**KIRKLEES METROPOLITAN COUNCIL
INVESTMENT & REGENERATION SERVICE**

DELEGATED DECISION TO DETERMINE PLANNING APPLICATIONS

Reference No:	2026/62/90785/W
Site Address:	21G, Station Street, Meltham, Holmfirth, HD9 5NX
Description:	Replacement of existing shopfront and enlargement of opening with associated external alterations (within a Conservation Area)
Recommending Officer:	Joanna Rednall

DECISION – CONDITIONAL FULL PERMISSION

east elevation

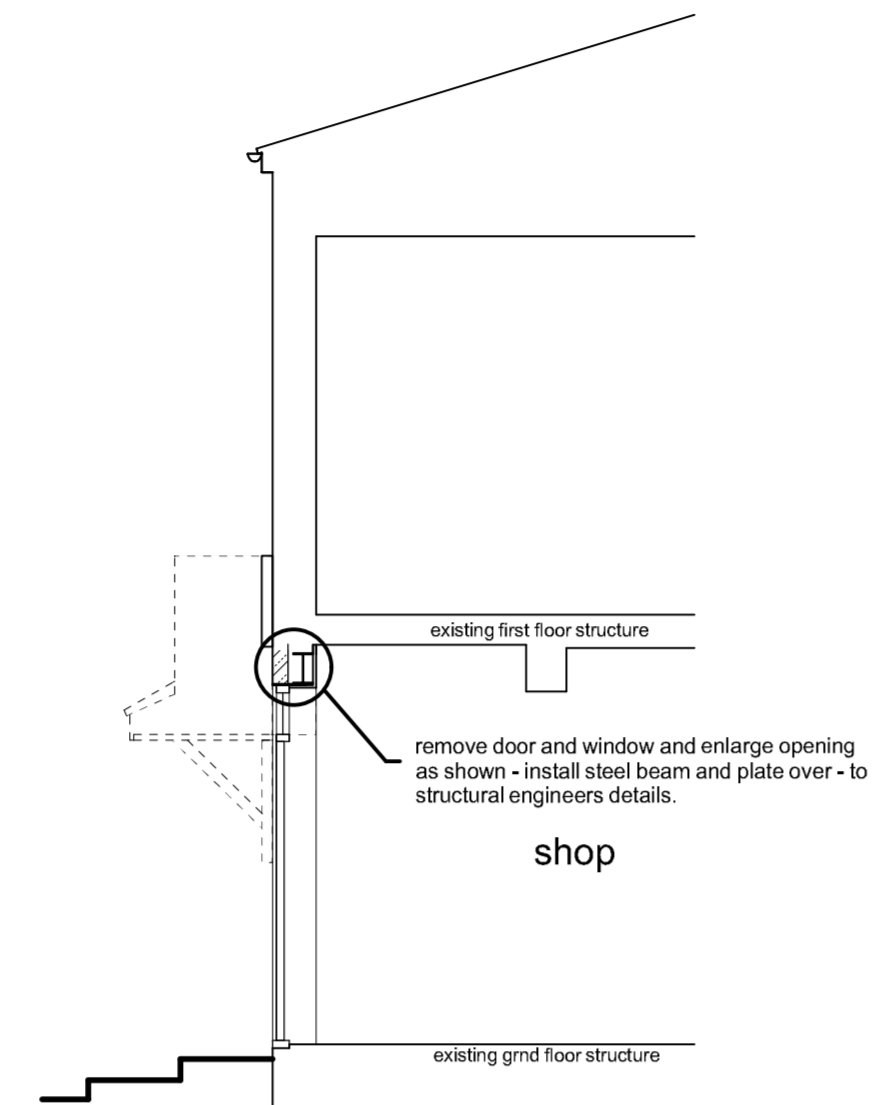
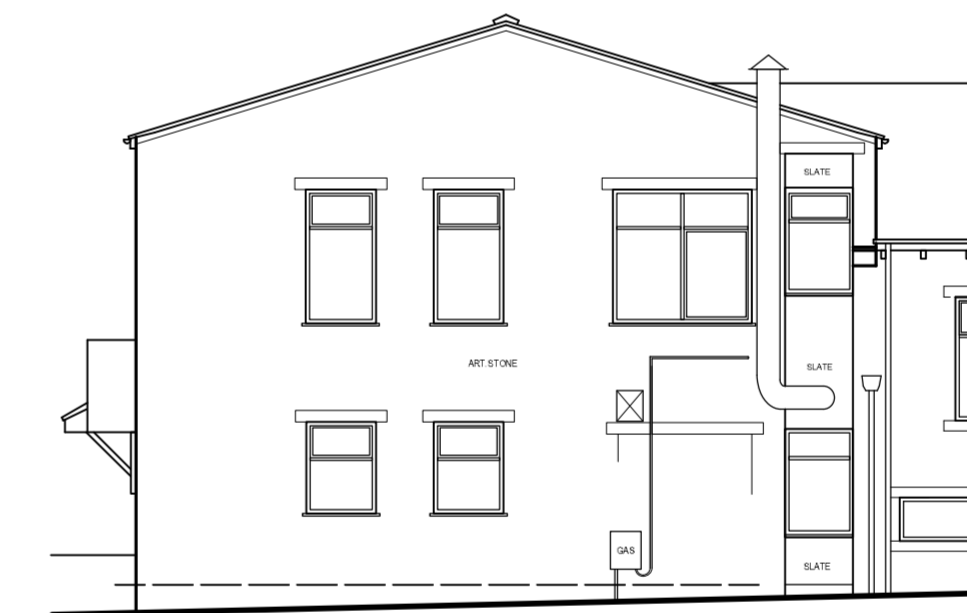
KC Conservation and Design: no objections subject to the shopfront being recessed 100mm from the front elevation of the building.

An informal consultation was undertaken with KC Conservation and Design, who raised no objection to the proposed alterations. Officers consider that any minor visual impact arising from the change in materials can be suitably mitigated through a condition requiring the shopfront to be recessed 100 mm

from the front elevation. The applicant's agent has confirmed agreement to this, and this recessing will help maintain a visual break within the frontage.

3. Notwithstanding the plans submitted, the shopfront hereby approved to the front / east facing elevation shall be set back in the reveal by 100mm and not fitted flush with the external wall.

north elevation

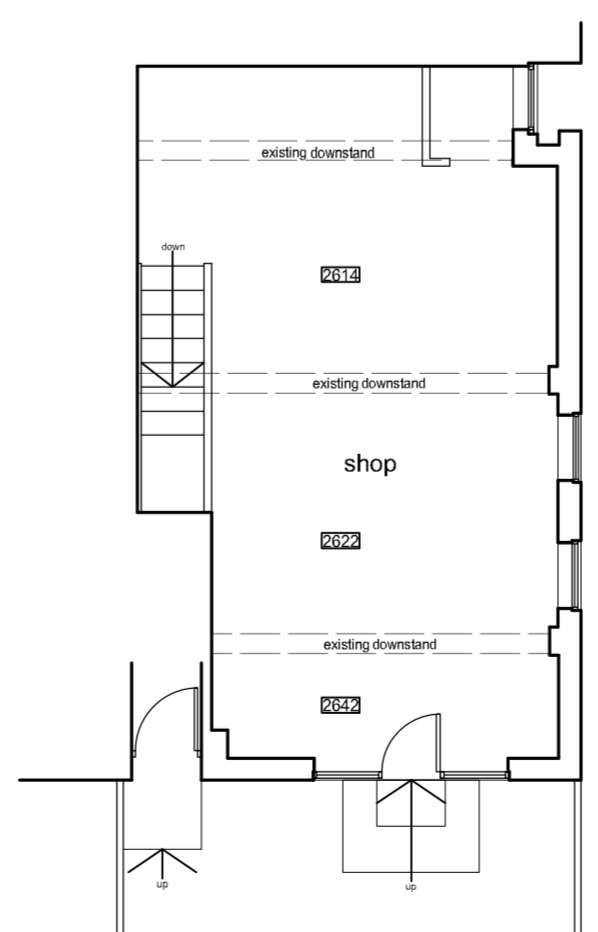
On the side (north-facing) elevation, a new grey aluminium external door with an adjoining side light is proposed. The combined opening would measure around 2.2 m in height and 1.4 m in width, including the slim window positioned alongside the door.

The proposed side door would face the blank gable elevation of No.23 Station Street and therefore would not introduce any new or materially different overlooking impacts compared with the existing situation. The relationship between the two buildings would remain unchanged in amenity terms.
